Our Ref: F2017/00247

**Re: Notice of exhibition of State Significant Development Application for the redevelopment of UNSW Cliffbrook Campus (SSD 8126)**

Thankyou for inviting Randwick City Council's comments on the SSD Application, Environmental Impact Statement (EIS) and accompanying documents for the proposed redevelopment of the UNSW Cliffbrook Campus (SSD 8126). Council raises a number of concerns with the proposal and attaches a detailed submission to this letter. Where appropriate recommended approval conditions are included. A summary of our main issues follows.

03 ELEVATION East Elevation 1:200

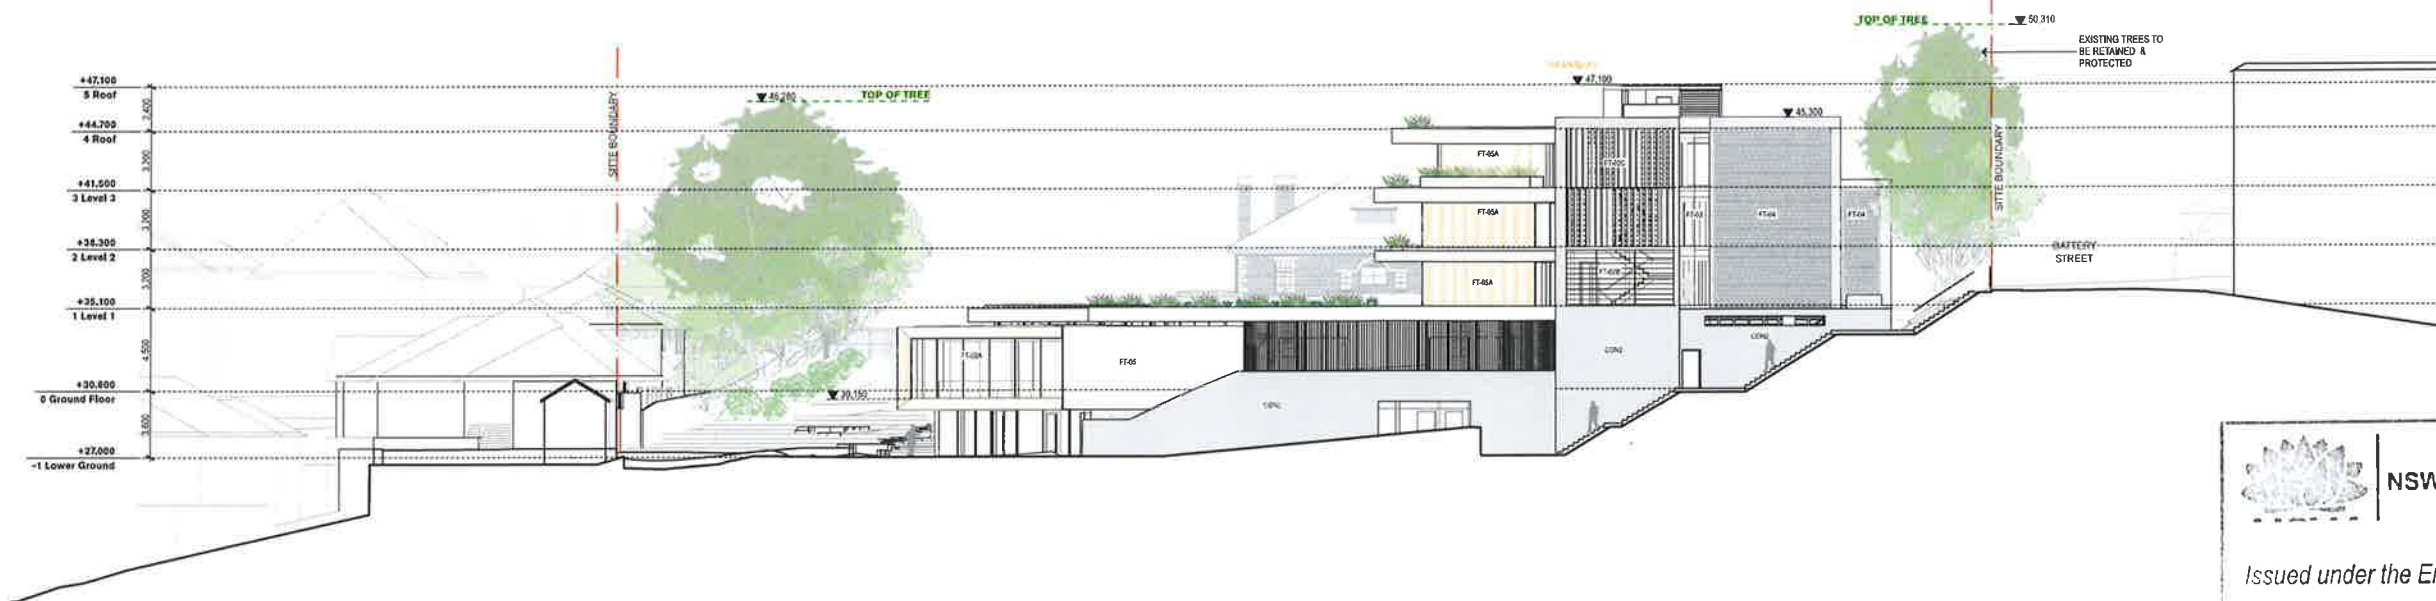
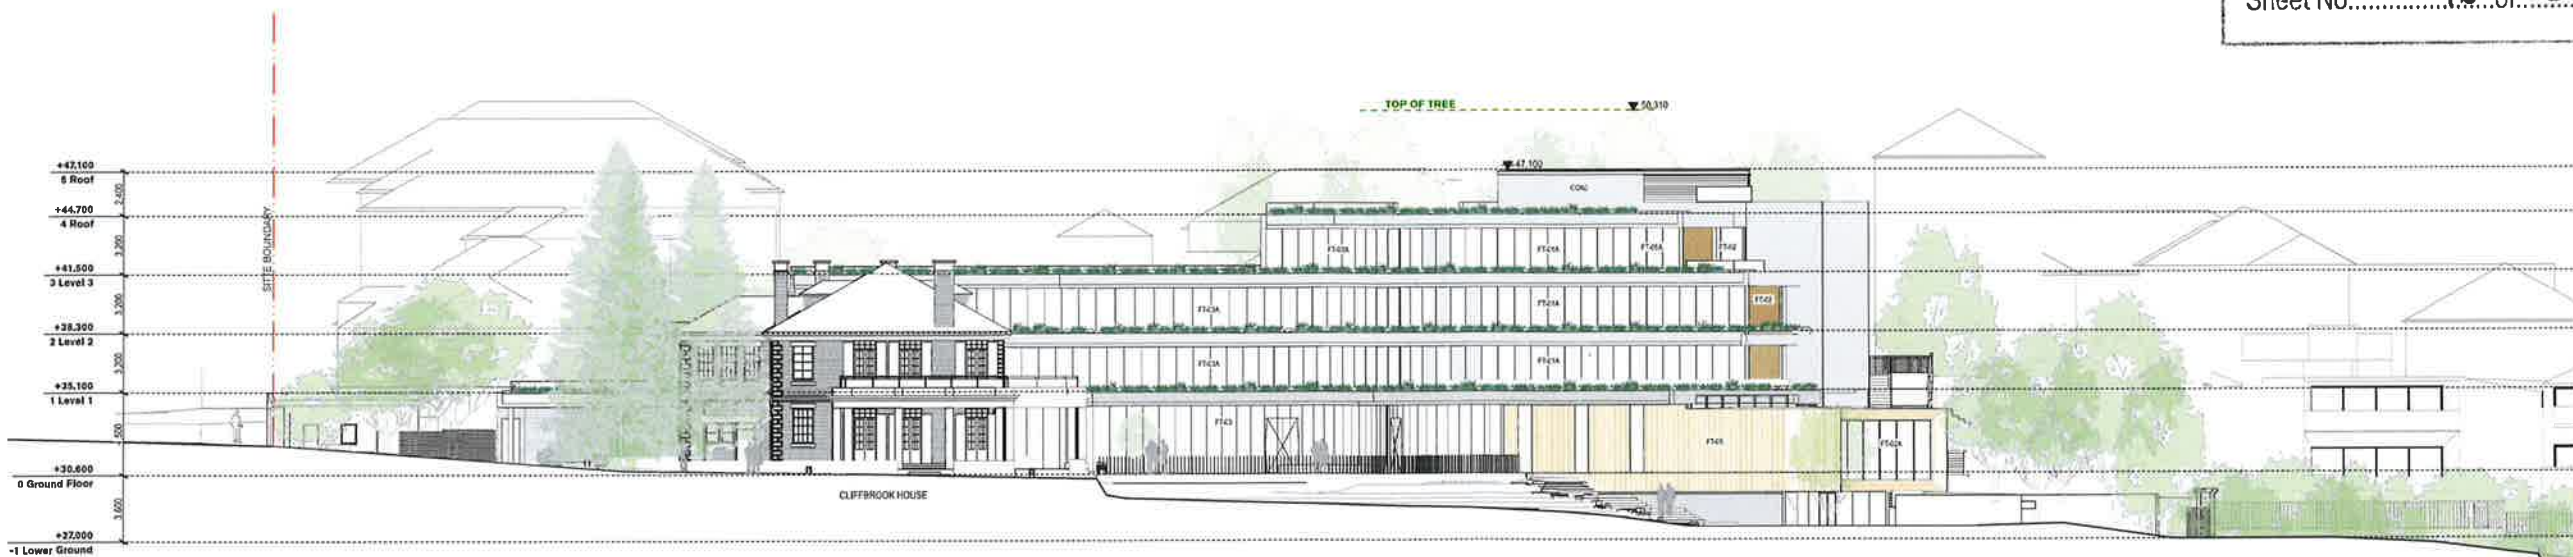
- The proposed building envelope appears visually dominant and overbearing in relation to the existing heritage item with the roof of level 3 of the proposed development two levels higher than the eaves level of the heritage item and the roof of Level 2 one level higher than the eaves level of the heritage item. It is noted that the proposed building will form the new backdrop to Cliffbrook house when viewed from the vehicular and pedestrian entry to the site from Beach Street. The drawings indicate an extensively glazed façade facing the heritage item with projecting spandrels incorporating planter boxes. The design of the new development should be reduced in height to ensure that the new building forms have a recessive and less overbearing backdrop to the heritage item.

- The height, bulk and scale of the proposed development does not achieve an acceptable relationship with other buildings on neighbouring sites, in particular, the existing one to two storey scale of dwelling house on the northern side of Battery Street.

sheet no. 5001

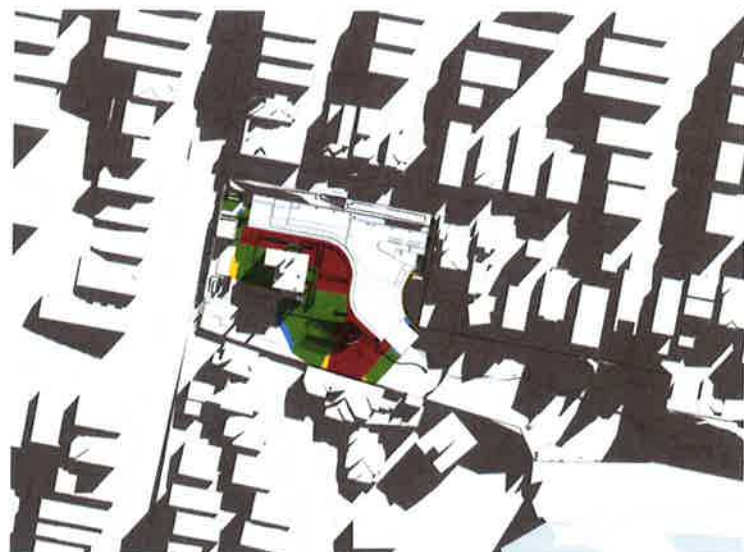
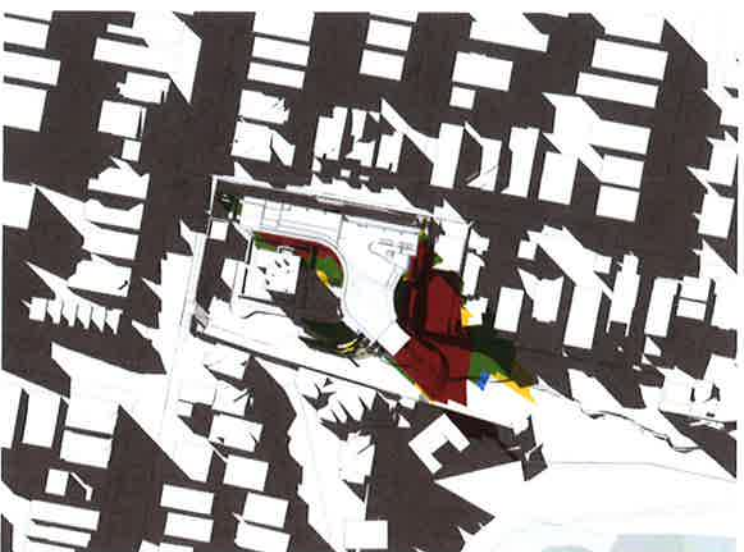
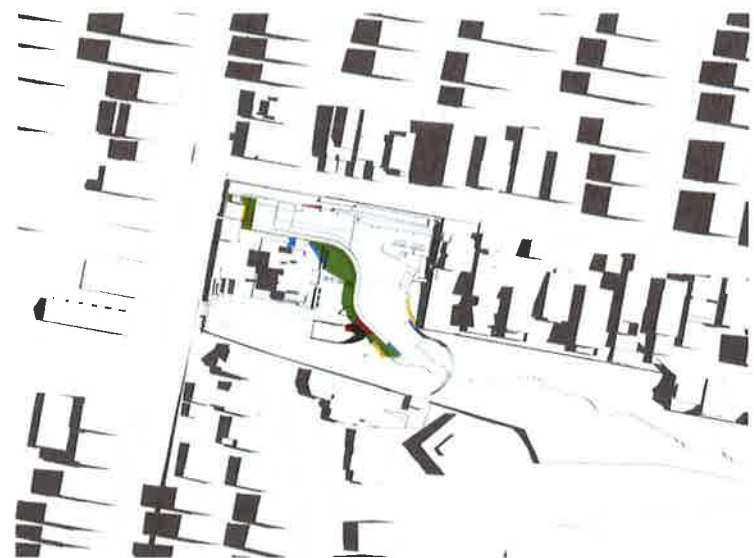
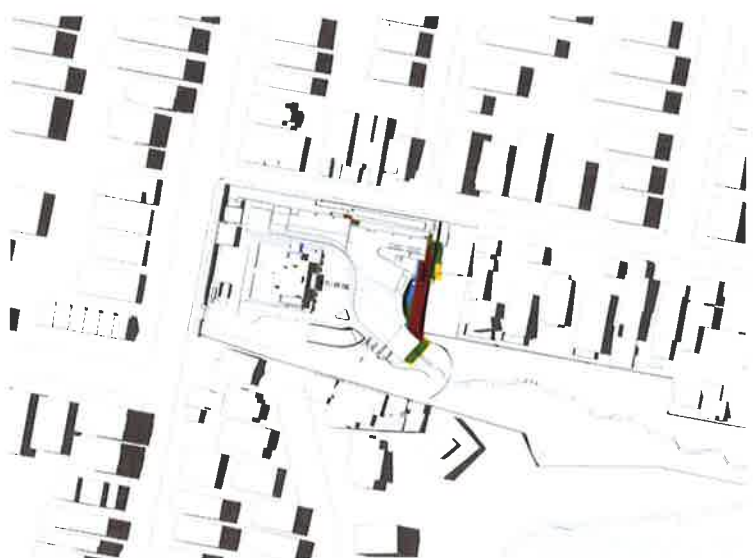
Council's DCP 2013 contains relevant criteria relating to solar access to neighbours to ensure adequate daylight to the main living areas of neighbouring properties and adequate sunlight to substantial areas of private open space in adjoining sites are maintained. The expected shadow impacts on the adjoining and nearby properties must be clearly shown. In this regard, Council queries the degree of clarity of the shadow studies undertaken in the EIS given the scale of the locality shown in these studies. Concern is raised regarding the overshadowing impact on the north elevation and curtilage of the heritage item which will be overshadowed by the enclosing wall of the proposed development all day during the winter solstice. Additionally, the impact of overshadowing on the south eastern open space within the development site should be addressed.
